C. Christian Berg, PE
Structural Engineer

March 3, 2025

Re: 340 Marion Ln, Spring Lake, NC

FOUNDATION PLAN

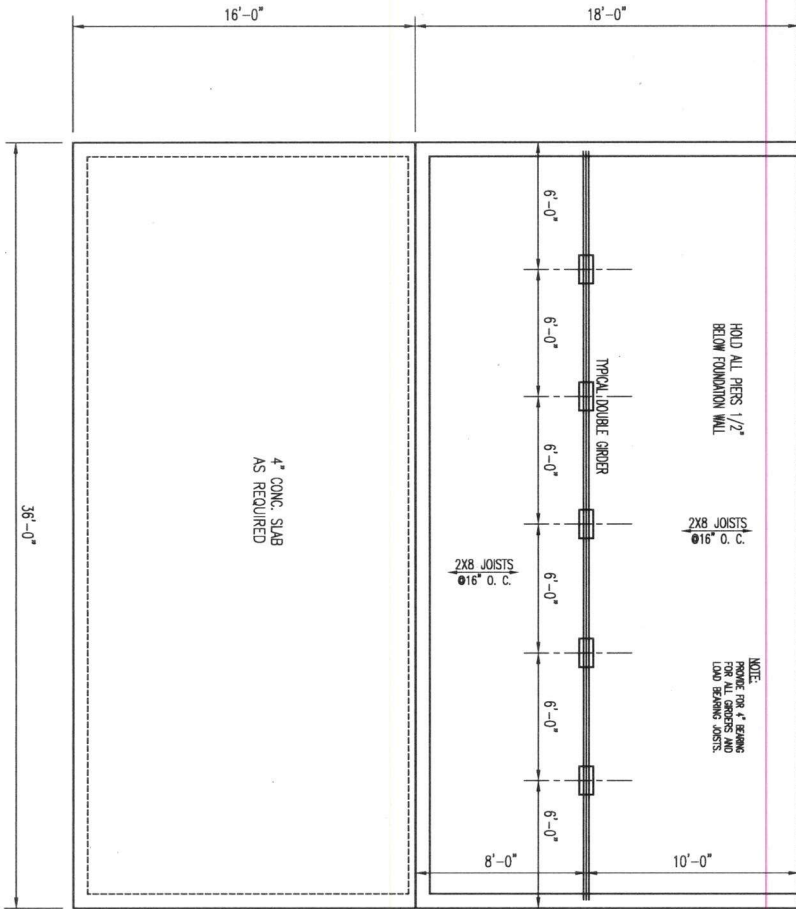
At your request, I reviewed the foundation for the addition being constructed to the home at the above noted address. In particular, one of the piers has been placed off center of the support beam. I have reviewed this condition, and it is my professional opinion that the placement of this pier will not adversely affect the structure of this home, and the foundation will safely support all loads required by the North Carolina Residential Building Code (2024).
